CITY OF PORTLAND, MAINE

PLANNING BOARD

May 20th, 2013

Project Name: **Commercial Development including gas station and convenience store with ATM**
Project ID: 2013-086 CBL: 237-A-012
Address: 2282 Congress Street, Portland
Joint Applicants: C J Developers, Inc. and Portland Property Holdings, LLC
Planner: Jean Fraser

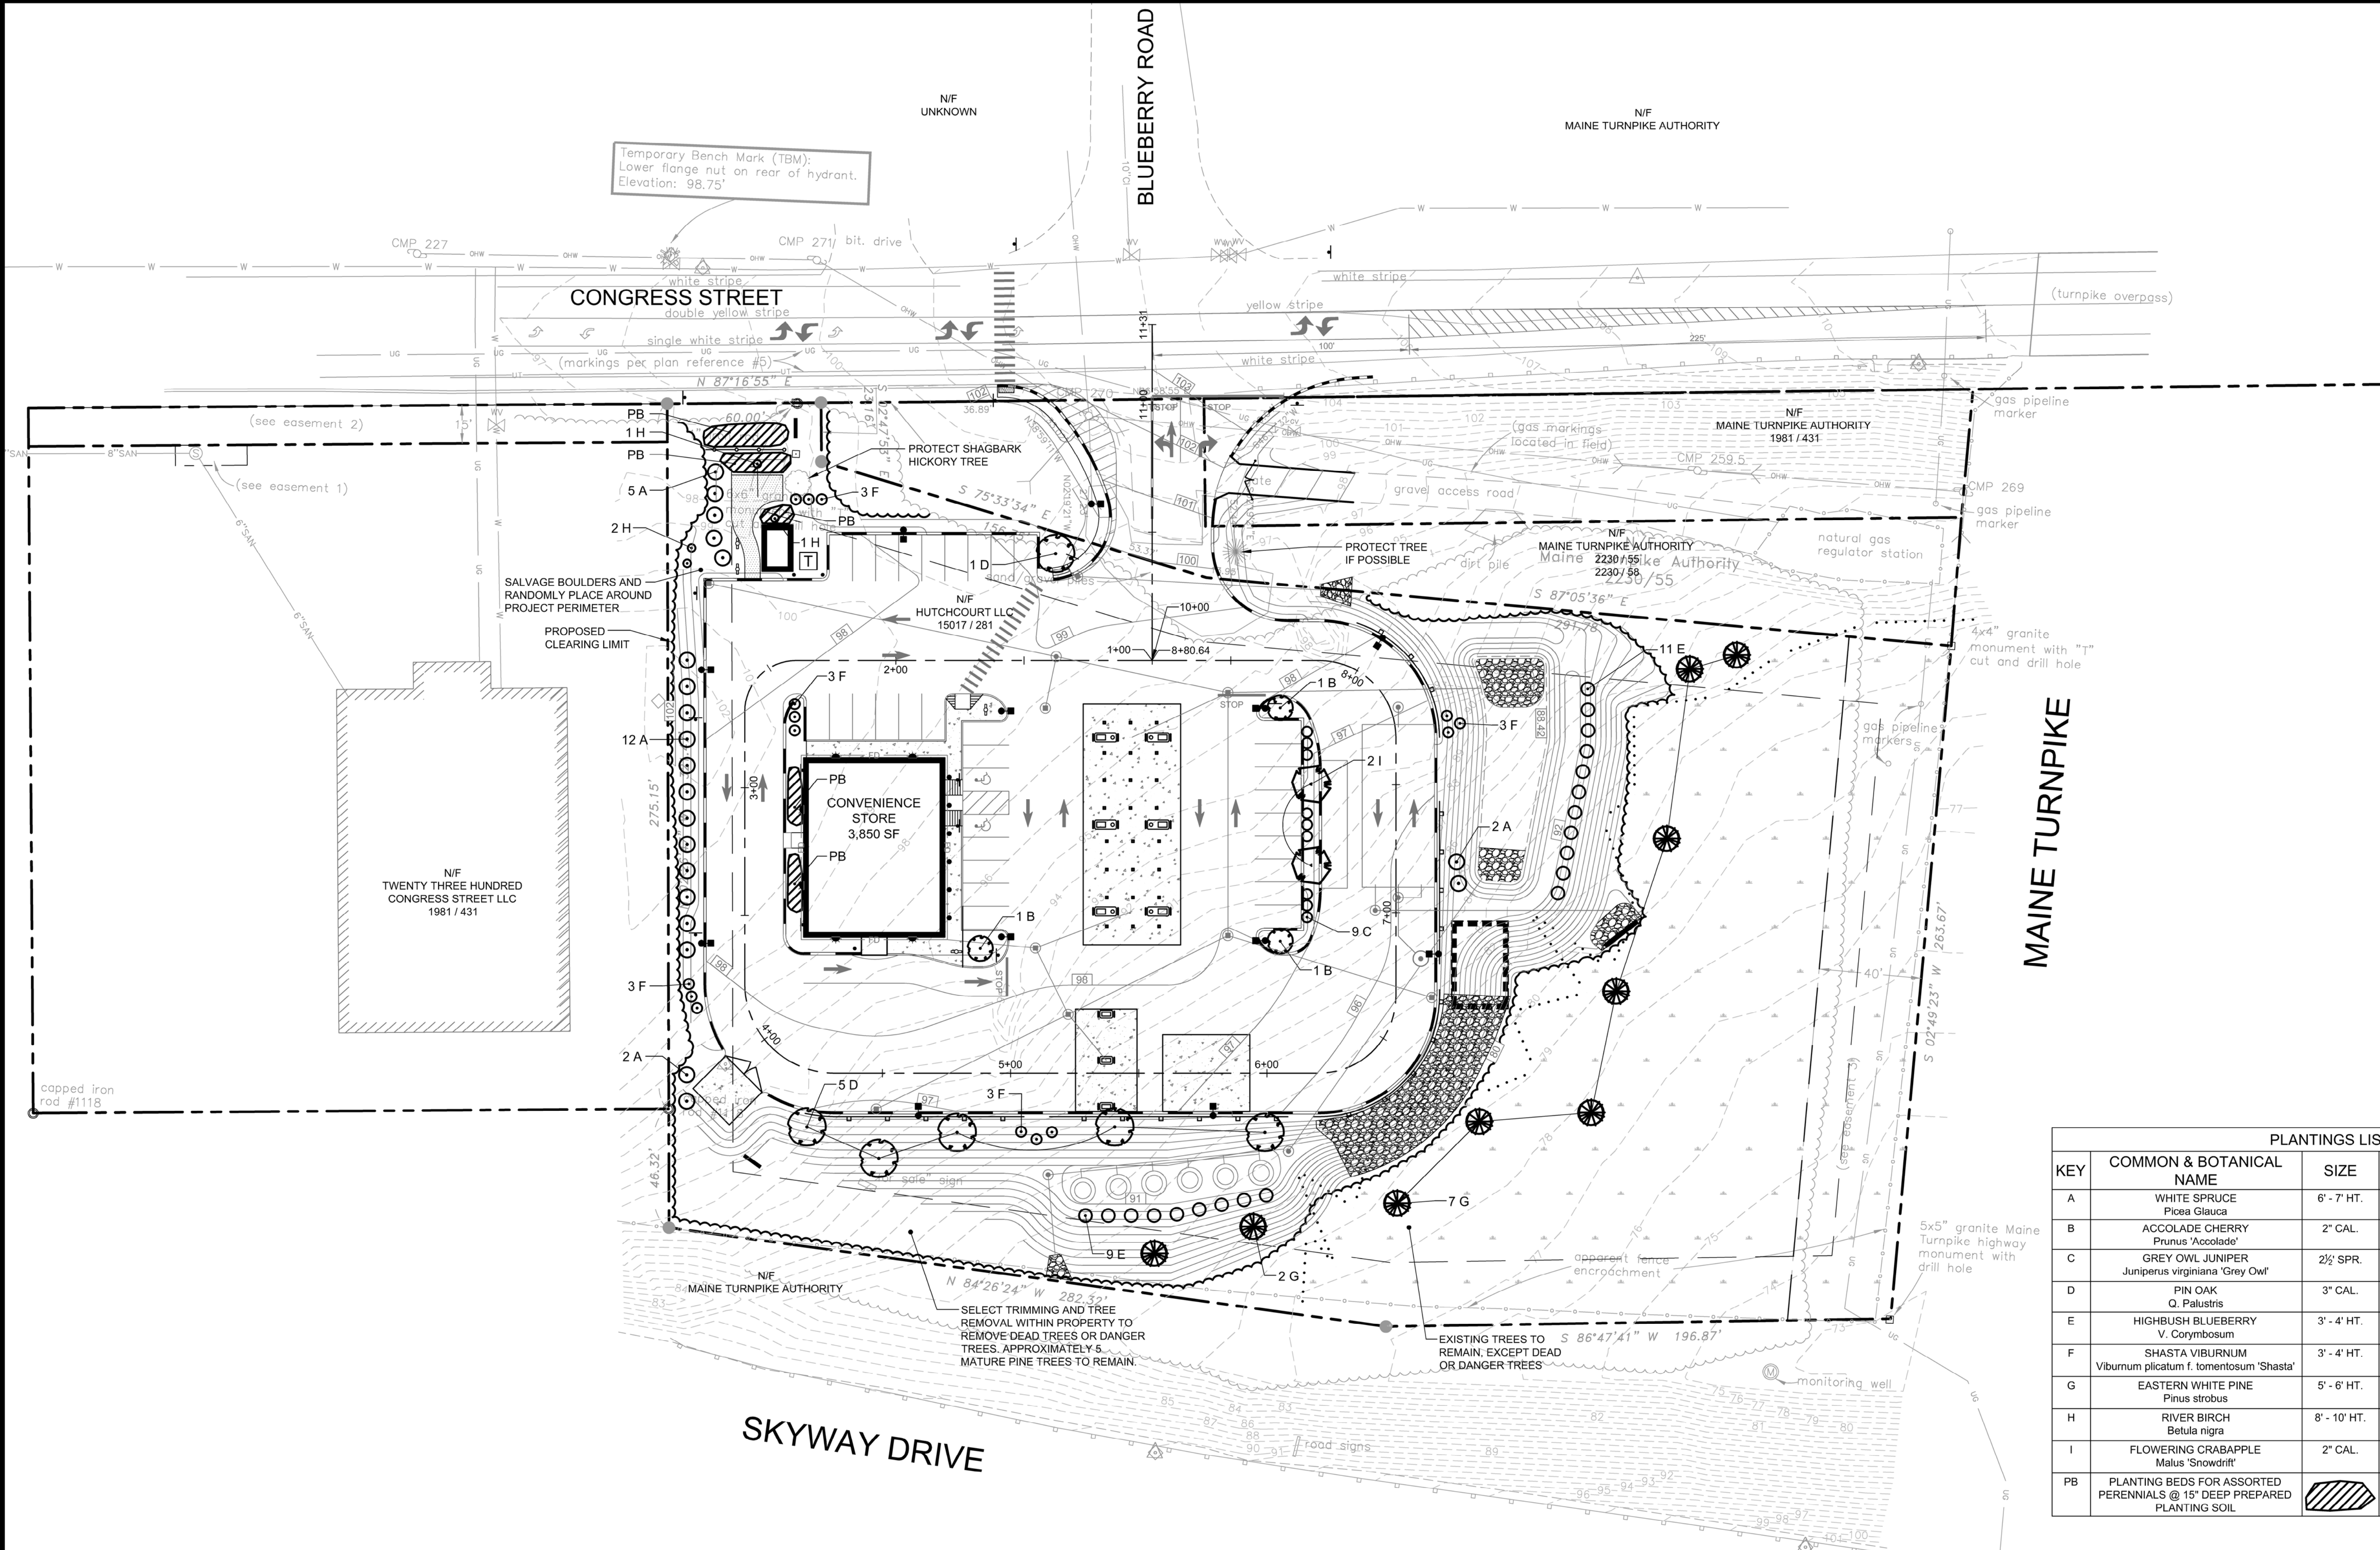
a) Tree Save - the 'tree-save', tree thinning area along Congress Street is improved and meets our recommendations. Additional 'tree-save' areas along the Western property line and towards Skyview Drive will need to be marked prior to site work and as approved by the City Arborist. There may be trees to be thinned or removed due to poor condition or risk. (Thinning trees for views is not recommended - thinning trees for safety and condition is.) Standard tree protection measures shall be used during construction, these include protection of tree root zones, identifying trees to protected, construction fencing or tagging where needed. No storage of equipment or construction materials in tree protection root zone areas. The area around the Shagbark Hickory is one of the tree protection zones.

b) Trees in parking lot - In the area shown as snow storage, and addition one to two trees could be set back away from the edge of pavement to still allow snow clearing and meet the parking lot tree / shrub standards.
